# Meeting Notes

Re: U-2509AB Concurrence Point 4B Meeting Minutes

J.R. Hopson opened the technical portion of the meeting by providing an overview of the natural resources in the general vicinity of the project to the merger team. He then provided a summary of the hydraulic avoidance and minimization efforts as well as stormwater treatment practices for the project. Following the overview, the preliminary drainage design plans were reviewed, sheet by sheet, and the following outlines the discussions held on each sheet:

PROJECT REFERENCE NO. U-2509AB	SHEET NO. 11
R/W SHEET NO. ROADWAY DESIGN ENGINEER	HYDRAULICS ENGINEER
INCOMPLETE PLANS DO NOT USE FOR R/W ACQUISITION	
DOCUMENT NOT CONSIDERED FINAL UNLESS ALL SIGNATURES COMPLETED

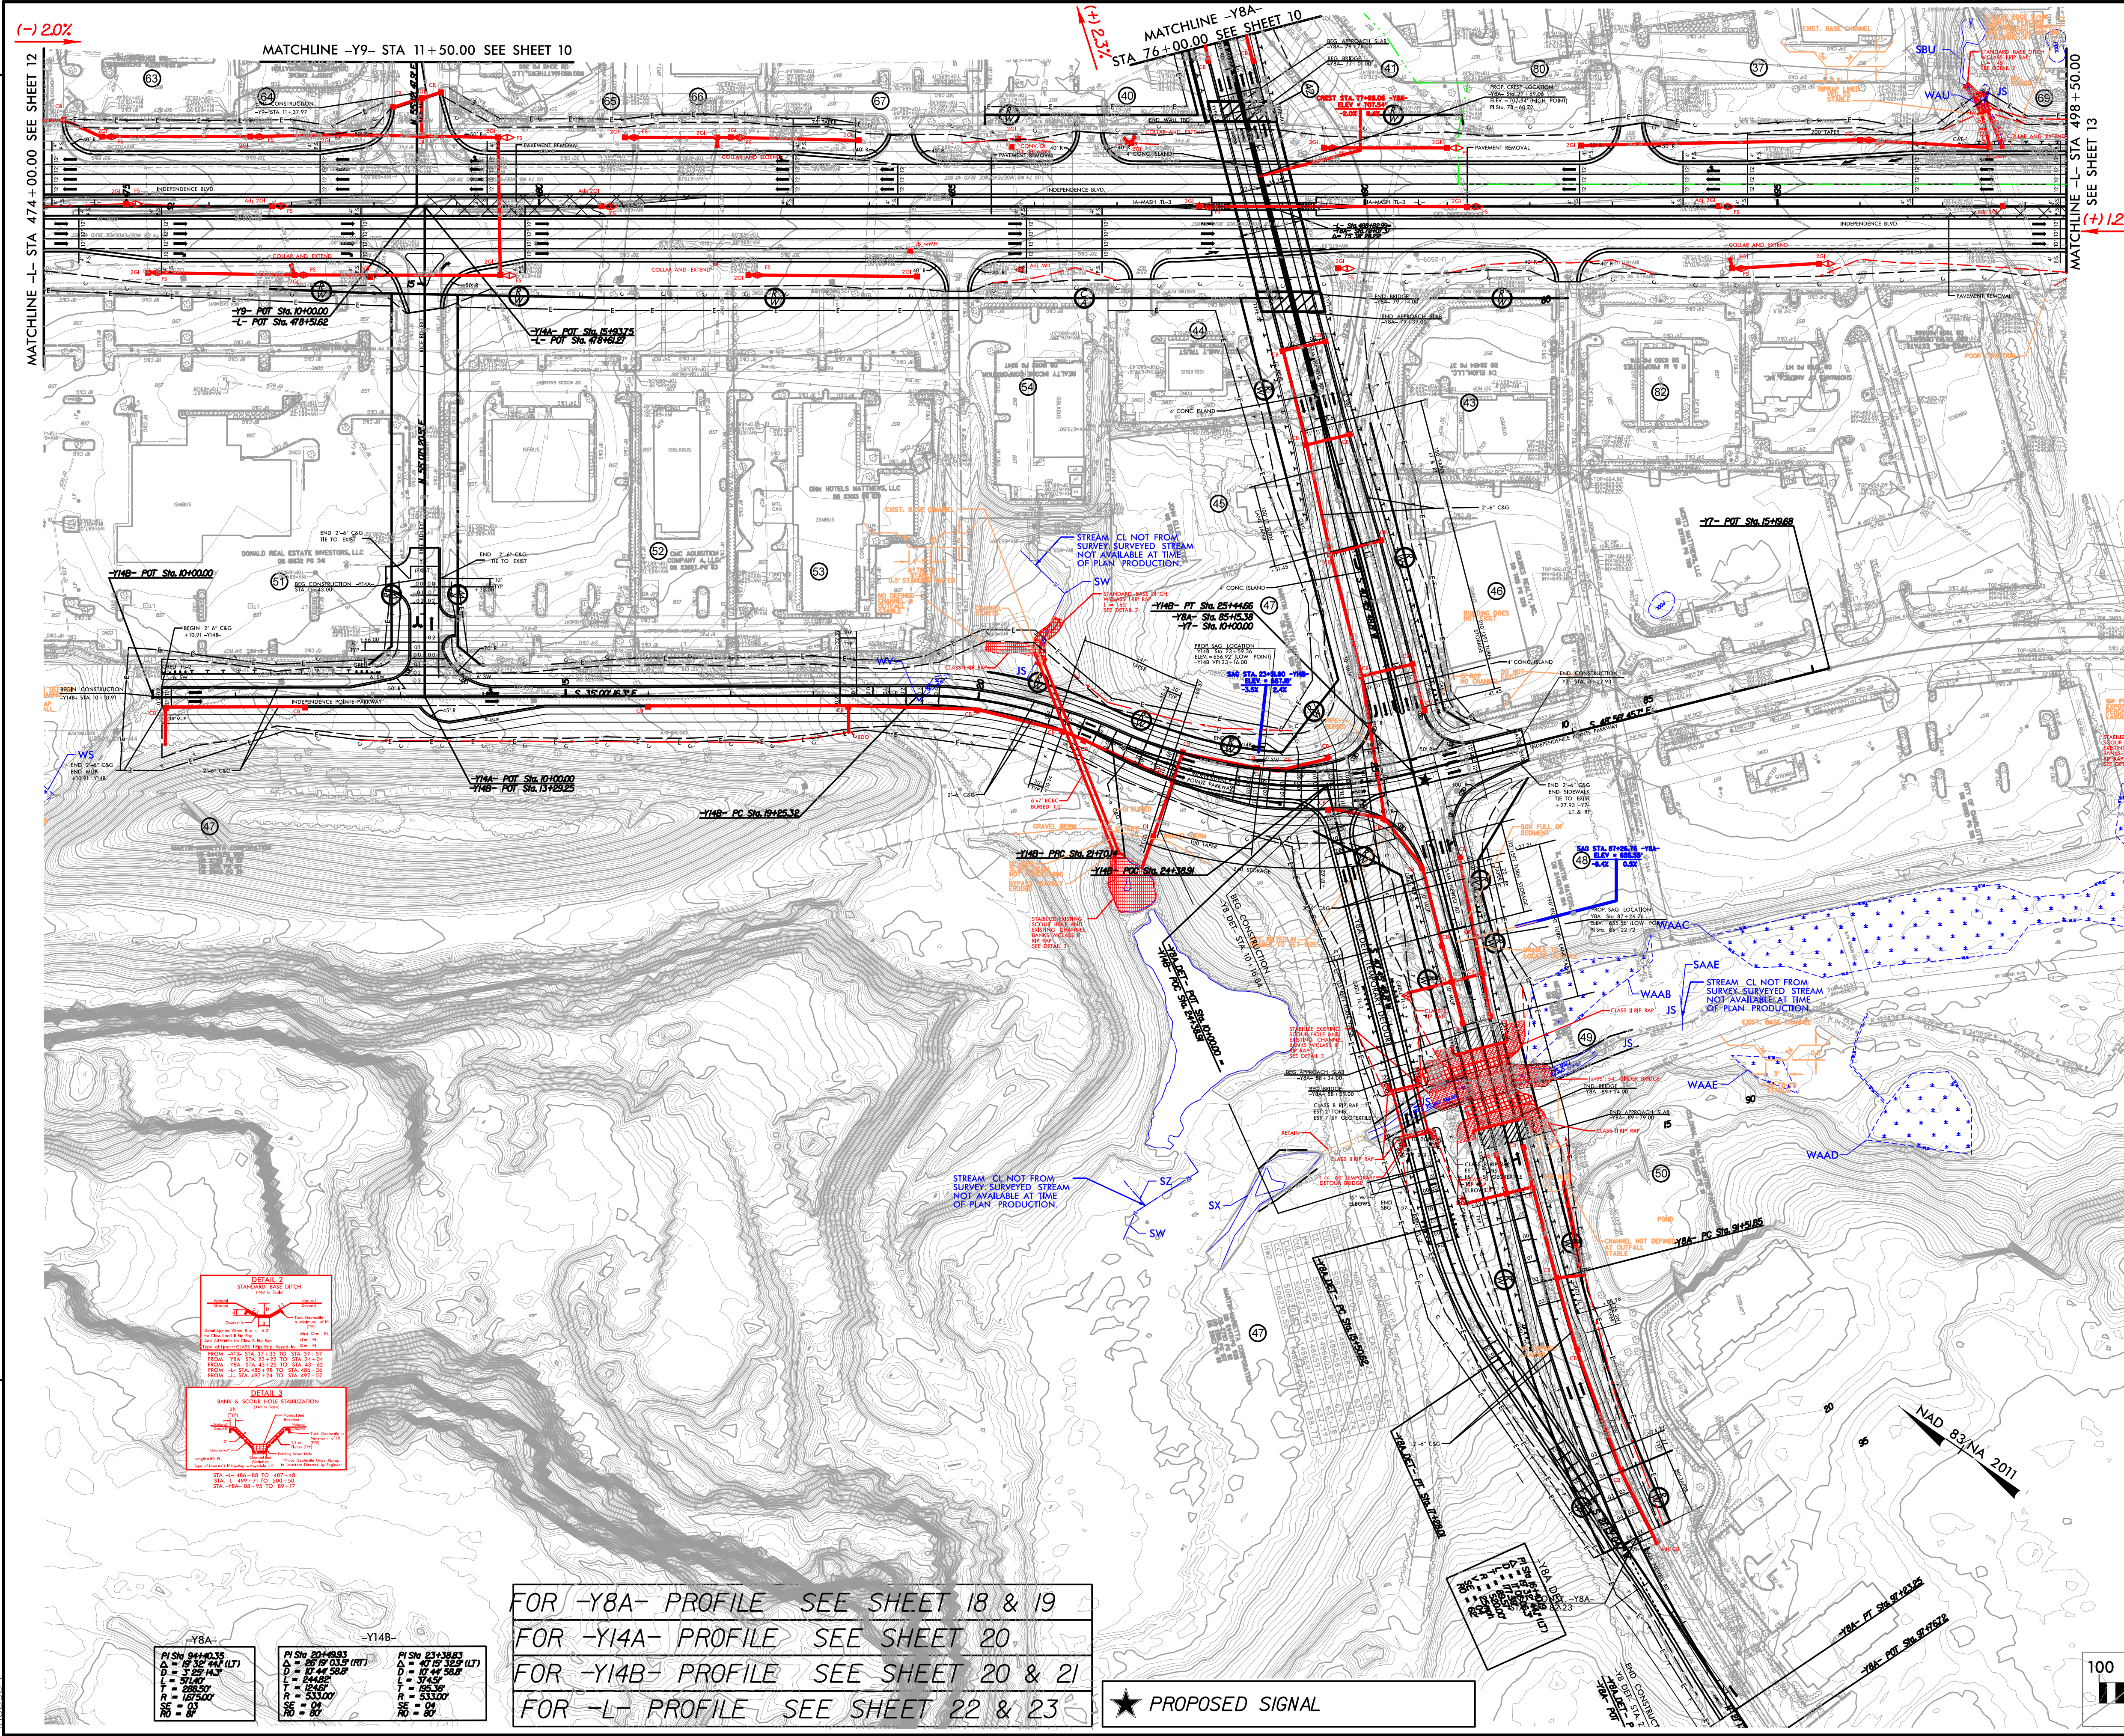
- Steve Brumagin and Dave McHenry commented that they appreciated the decision to go from a culvert to a bridge. Lauren Triebert noted that the greenway under the bridge was a green sheet commitment for the project which subsequently led to the roadway grade being raised.
- There were concerns about the 60" CMP culvert immediately downstream of the bridge may get blown out. However, the team noted that this culvert is under a private gravel haul road and that anticipated structure velocities approaching the haul road should improve due to the removal of the existing culvert and placement of the bridge structure that will allow the stream floodplain access. This structure is anticipated to fall outside of NCDOT's ROW.
